Our Ref: R/2016/1/C
File No: MP 08_0098 MOD 13

Modification Request for The Star (MP08_0098 MOD 13) – 20-80 Pyrmont Street, Pyrmont

The City of Sydney (the City) has reviewed the information provided as part of the public exhibition and **objects** to the Section 75W modification of the project approval.

Figure 1: Location of tower within the context of approved and proposed development in Darling Harbour

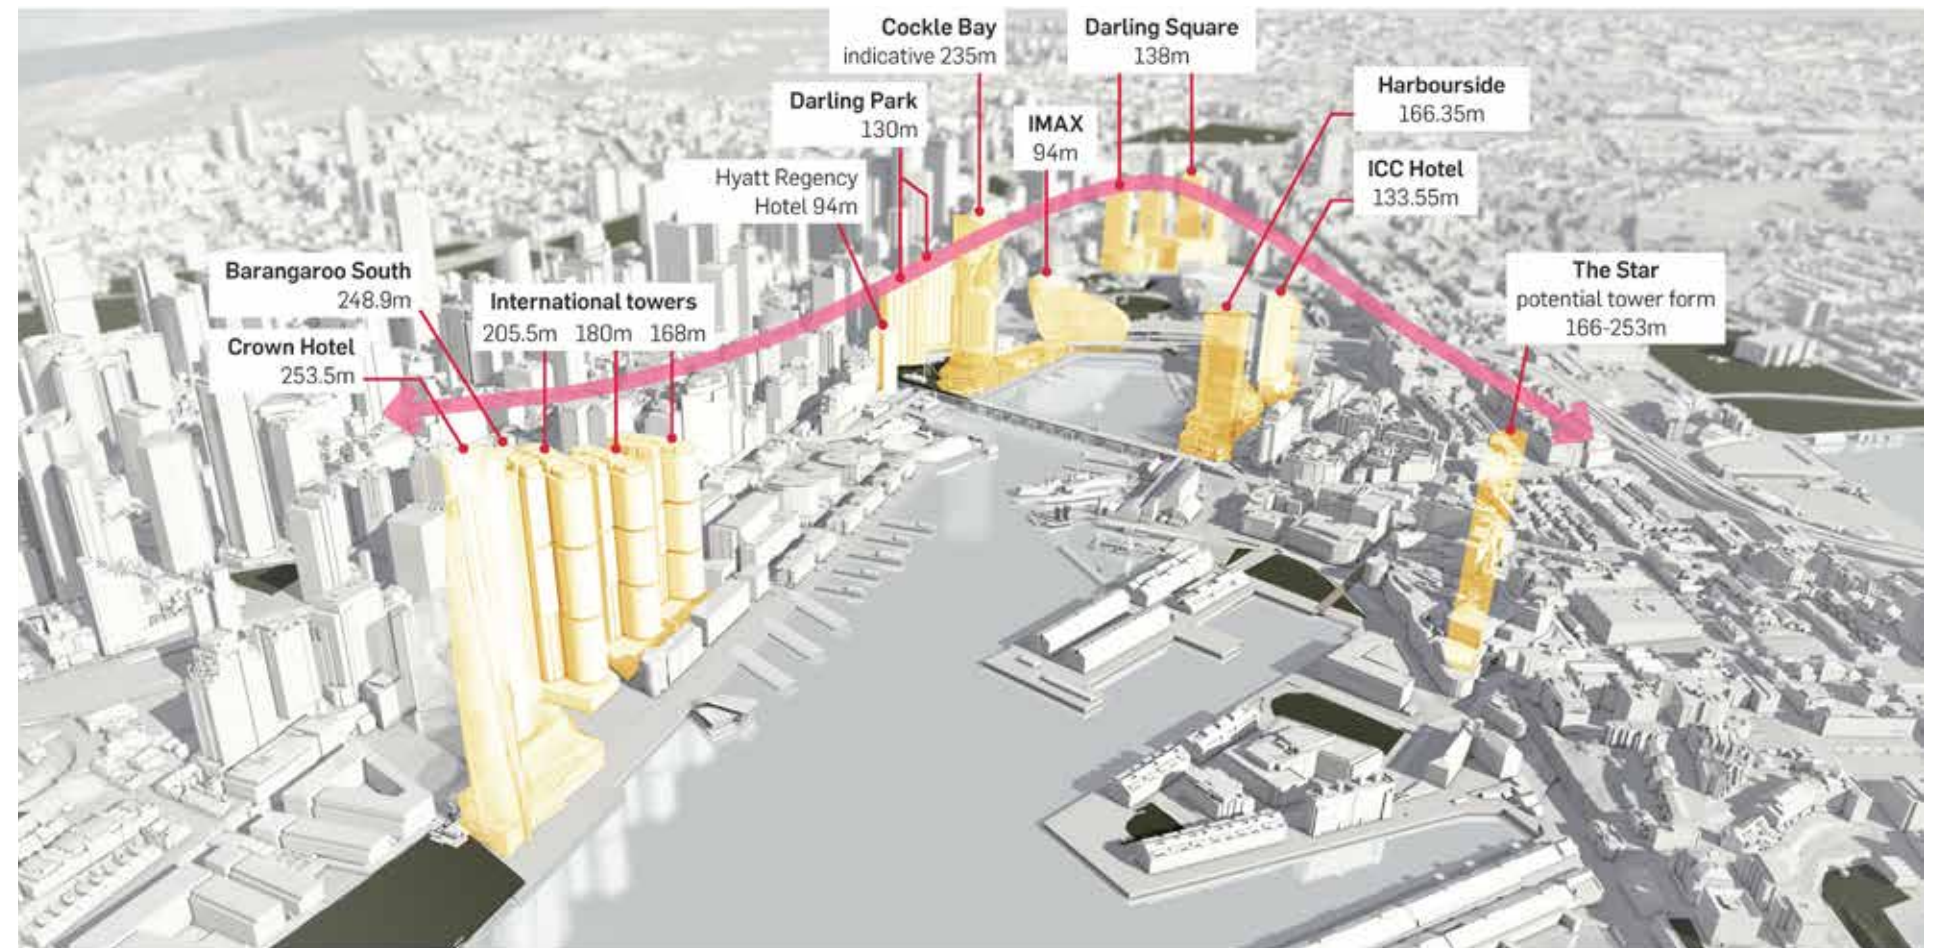
15. Figure 1 in the visual impact assessment prepared by Architectus provides a “context” to justify the tower that exists outside of Pymont. It is clear from the view assessment on Cockle Bay that there is no context of towers in the Pymont vicinity. Nor is there a proposed or approved future context of towers.

4.1 Neighbourhood Centre

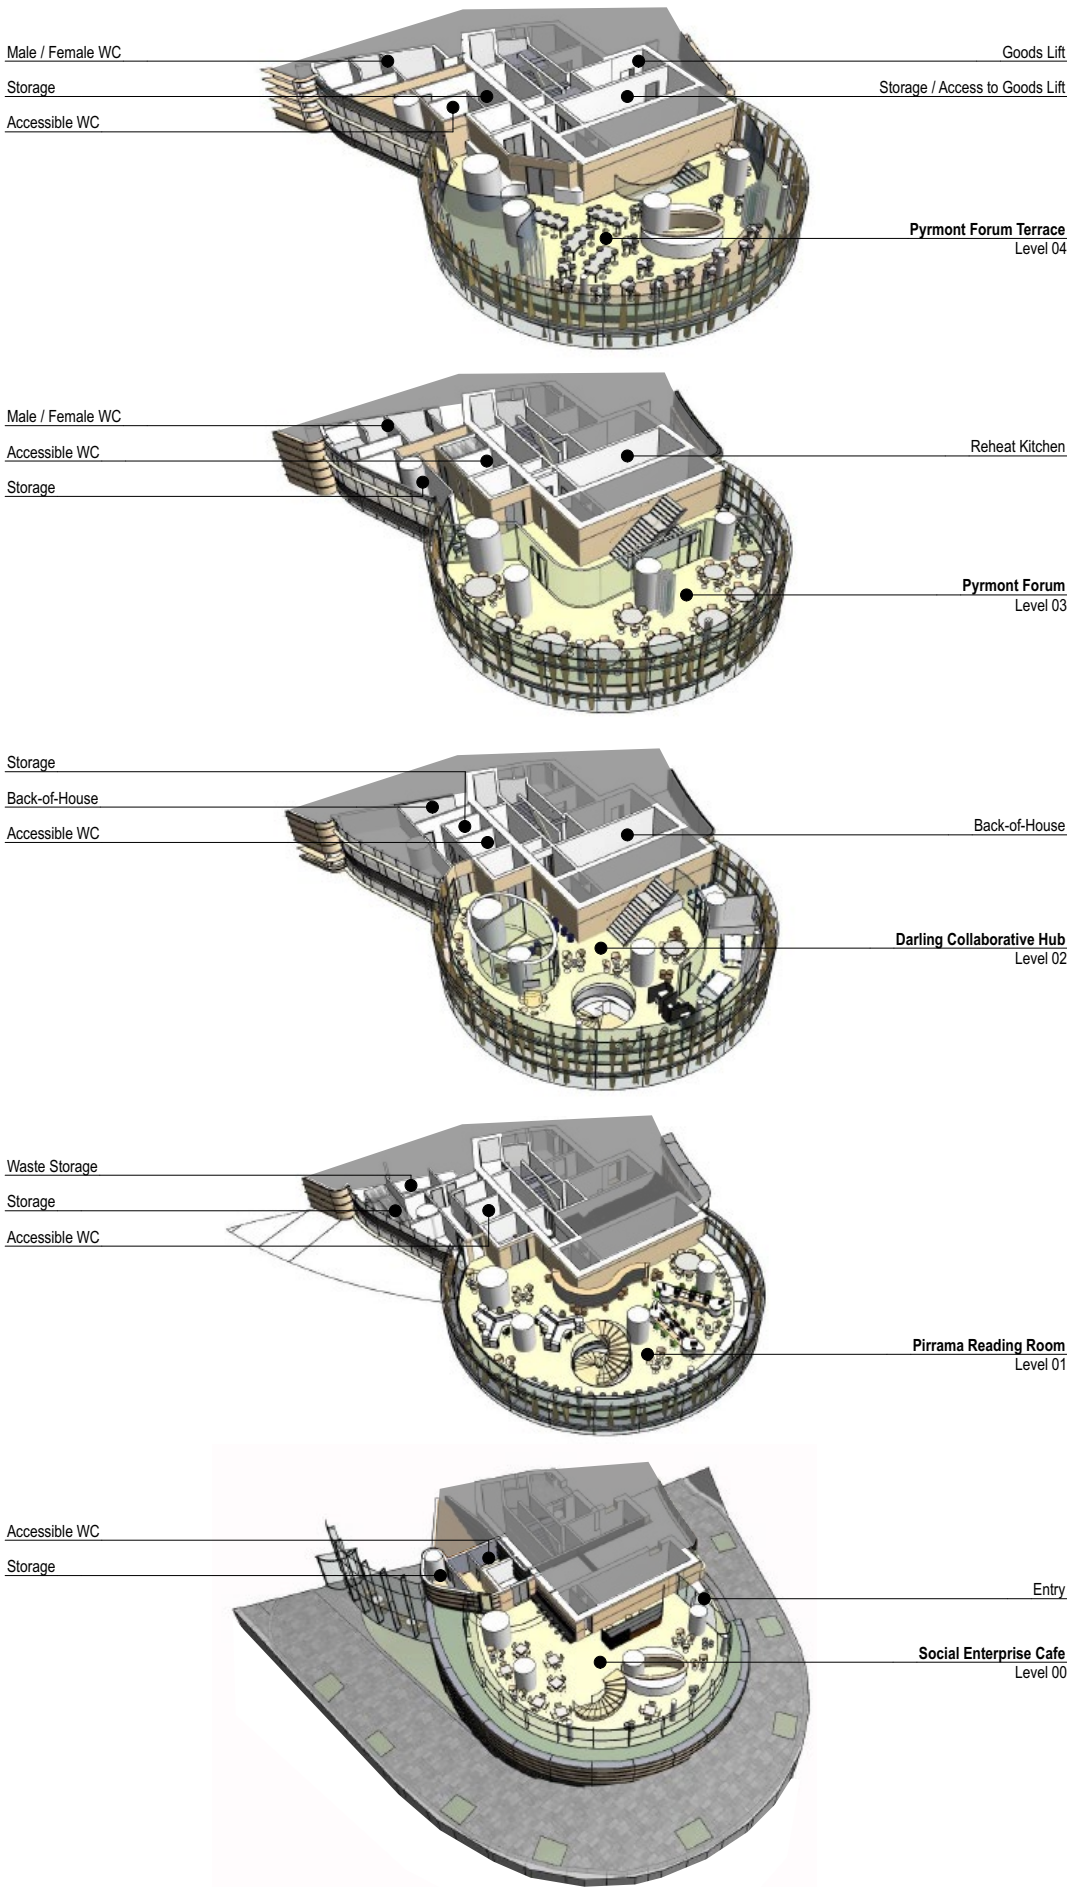
While the City is prepared to raise no objection to the inclusion of a 'Neighbourhood Centre' there is distinct lack of detail within the submitted documentation about how it will be managed and operated, about whether it will be a bona fide facility for the whole community (as opposed to the community within the building), and certainty about it remaining a genuine community facility for the long term (notwithstanding any future change in management and/or ownership). The degree of detail required to allow a full and proper assessment of the application has not been provided. There is no certainty that the centre can successfully operate and function for the community.

Given the irregular curved shape of the proposed Centre, the space and its operational needs have to be well thought out in order to successfully function. To be a successful multi-function space the Centre will need to be flexible while accessible, and provide various size spaces to serve the various community needs. Adequate 'base' facilities (eg. rooms of various sizes, kitchen, direct access to the loading dock; and adequate storage for furniture and the like) should also be provided.
